**Re Planning Application No. AW/344/14/HH - 68 The Drive, Craigweil**

As owners of the neighbouring house we wish to register our objections to the above plans as follows:

Drq No.	Rev
68/2014/60P	A

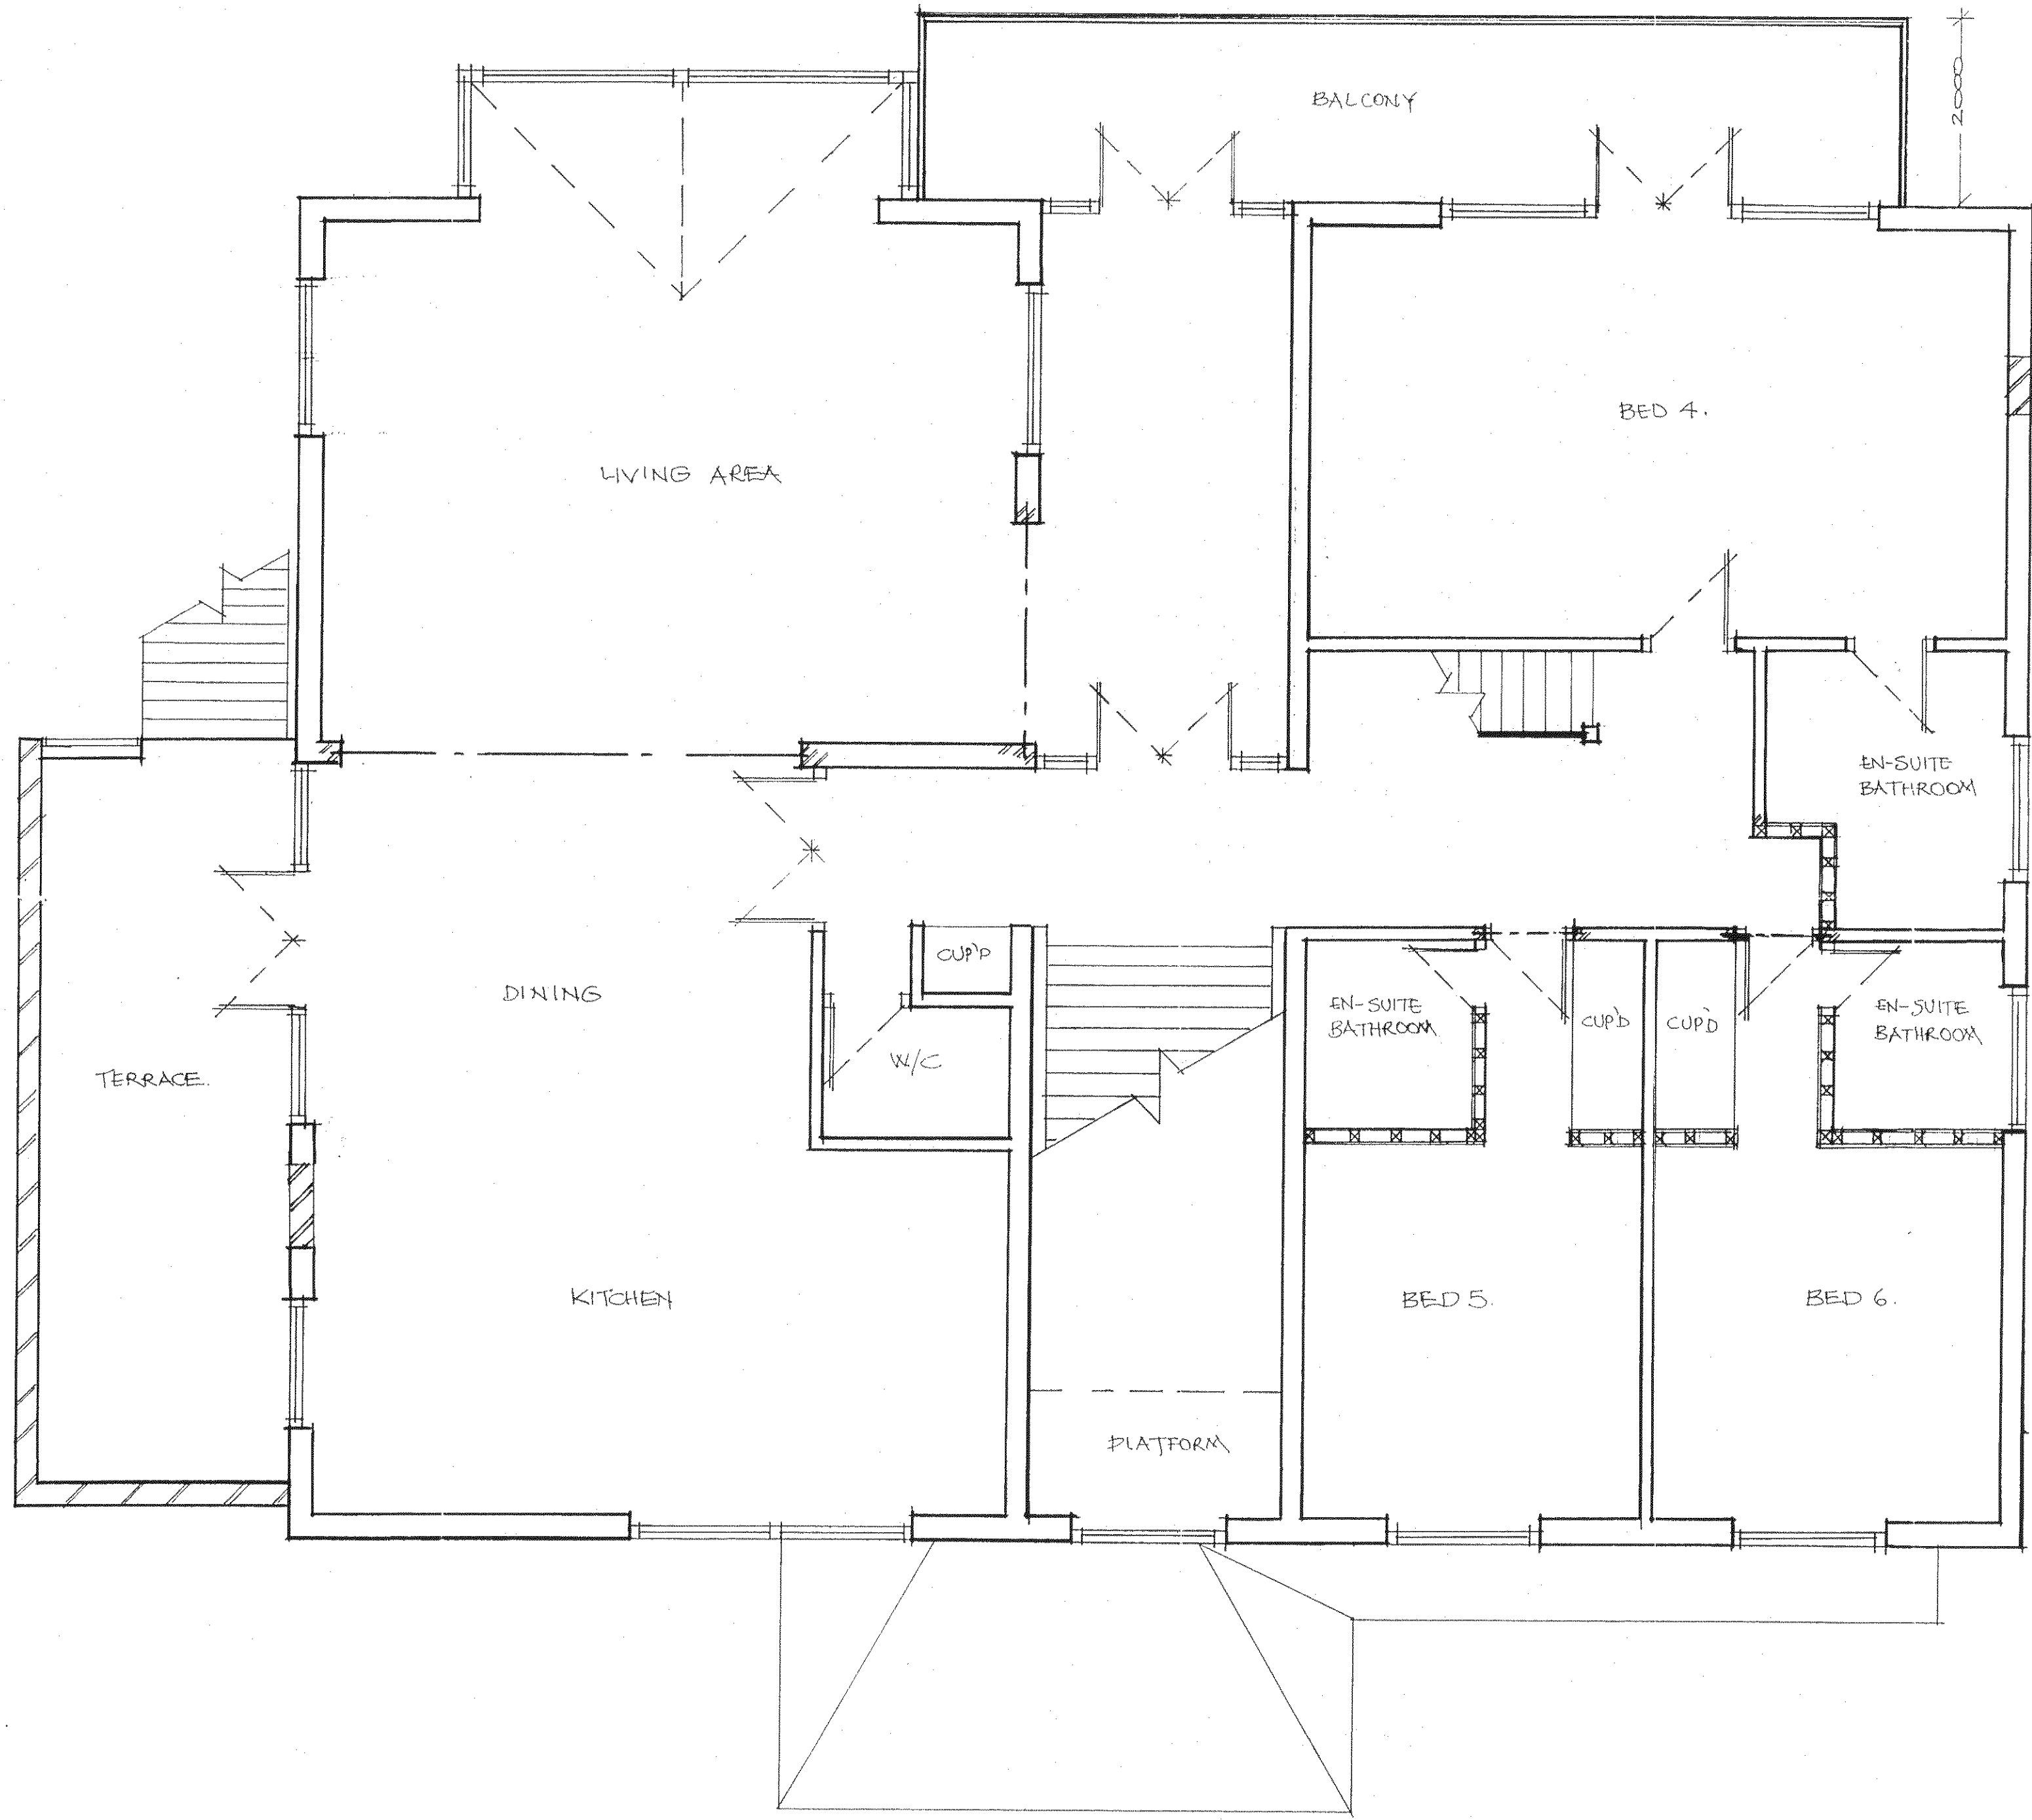
**1. New external steps at rear of side extension and associated "Terrace" as indicated on Document 68/2014/30P Rev. B and Document 68/2014/60P Rev. A**

The plans provide for the main external staircase at the rear to be dispensed with, thus making the stairs on the eastern elevation the only external access from the first floor. It is reasonable to assume therefore that this would generate a doubling of traffic on those steps from which we have already experienced significant noise intrusion with loud phone conversations being conducted on the staircase. The plans seem to provide for what is termed a "terrace" on the first floor eastern elevation. The proposed terrace is both wider and longer than the current access to the steps and seems to us to have been designed to accommodate a degree of external living. It would appear to have potential for the noise level to increase and for even greater intrusion into our privacy. It is certainly a change of use from the existing arrangement.
